Ribble Valley Borough Council  
Housing & Development Control

Application no: **3/2021/0725**

Address: **Buck Inn Sawley Road Grindleton Lancashire BB7 4QS**

Proposal: **Proposed replacement two-storey side and single-storey extensions to rear, external and internal alterations including first floor conversion from manager's accommodation to four toilet ensuite bedrooms.**

Drawing Title
 EXISTING SITE PLAN

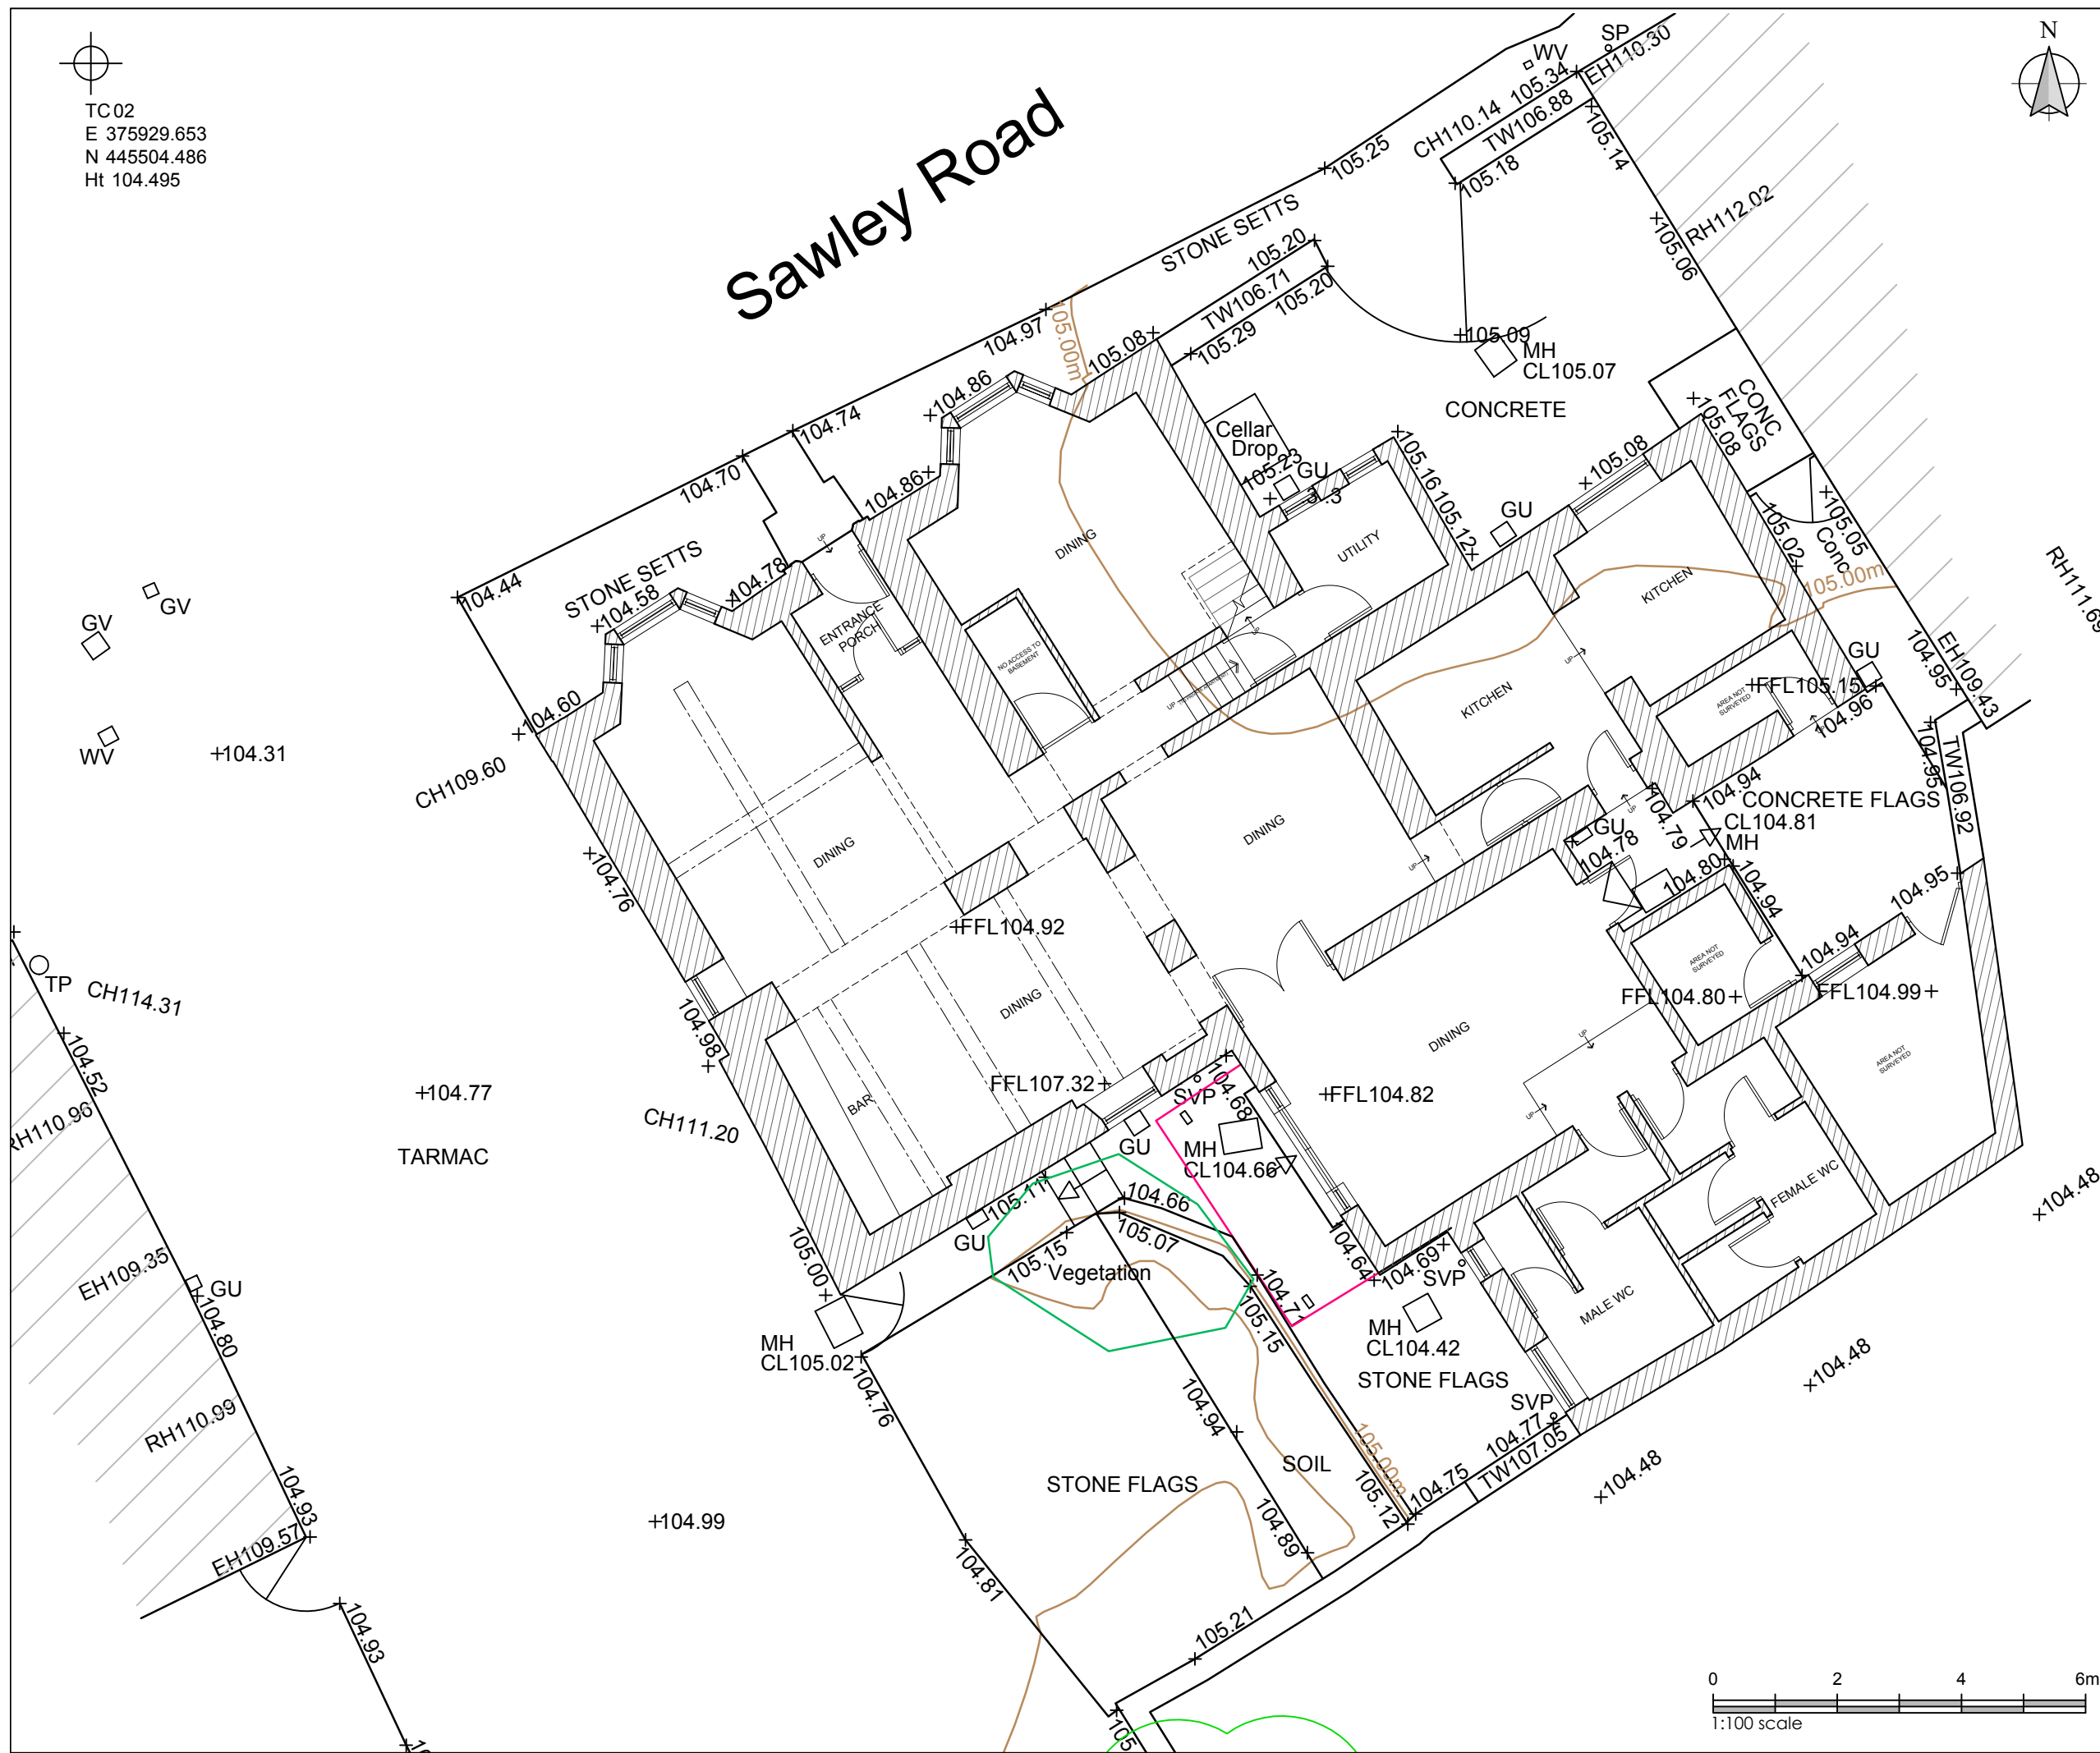
Applicant should submit an existing car parking plan detailing how many car parking spaces can be provided on site. This will allow for the LHA to compare the proposed and existing parking plans as well as identify whether any spaces have been removed due to the proposed extension of the building.

**6239 - P01** REV B

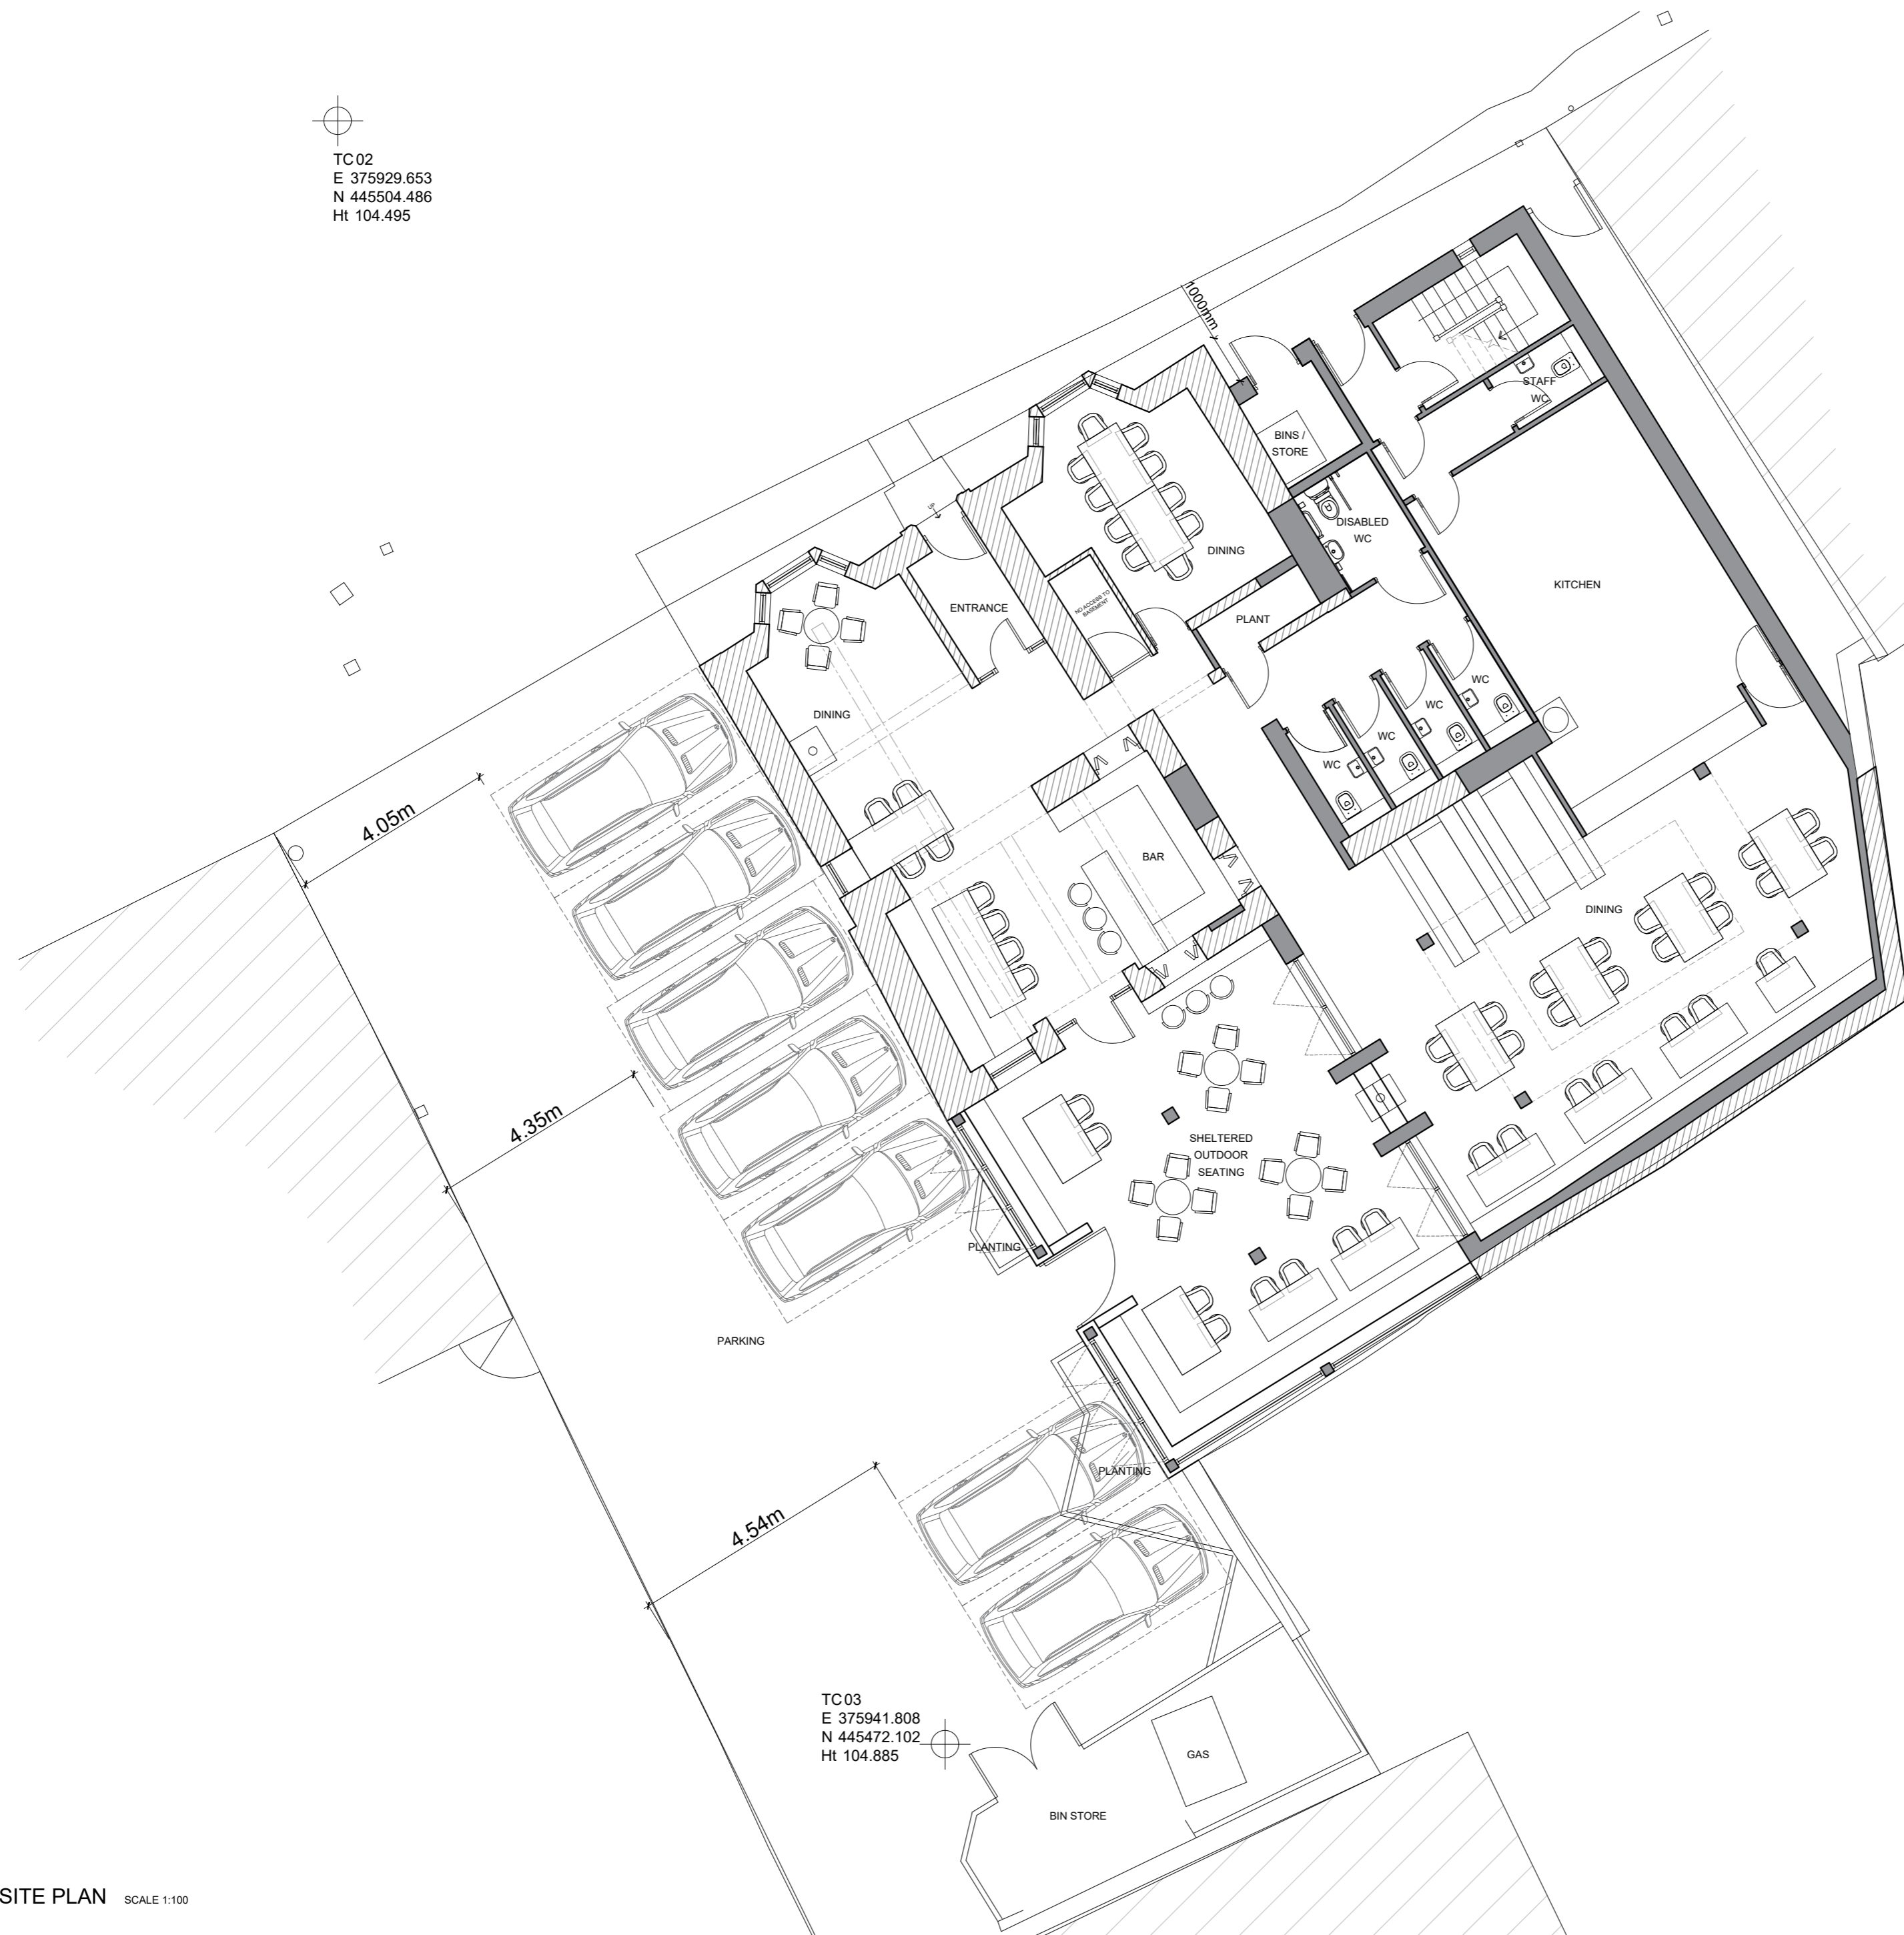
However, the LHA have reviewed SPA drawing number 6239-P01-Rev A titled "Proposed Site Plan" and understands that the site can only provide 6 car parking spaces for the proposal. Therefore, the site has a shortfall in 29 car parking spaces.

Notwithstanding this, the LHA have reviewed the drawing and understands that the parking layout at the site could be improved, allowing for the site to increase the number of car parking spaces provided.

The LHA advise the Applicant a way to increase the number of spaces is by providing the spaces in a more traditional layout rather than at 45 degrees to the building. Not only will this increase the number of spaces available at the site but will also prevent any highway safety concerns associated with the use of the first car parking space, as shown on the drawing. This is because currently the LHA are concerned should the space be used, that vehicles will be reversing onto the public highway to exit the site due to the angle of the space, meaning that a collision could occur between the vehicle exiting the space and vehicles using the highway. However, should the space be at a more traditional angle, the vehicle will be able to reverse out of the space on site and enter the public highway in a forward gear which would be safer.

The LHA also require a swept path analysis of the largest delivery goods vehicle who will use the car park when delivering goods to the proposal. The LHA require a swept path analysis to ensure that vehicles can easily enter and exit the site.

For the LHA to support the proposal, the LHA require a site access plan, a revised parking layout drawing, a swept path analysis of the largest delivery goods vehicle and further information in the guise of an existing parking plan and Operation Statement to allow for the LHA to fully review the application.
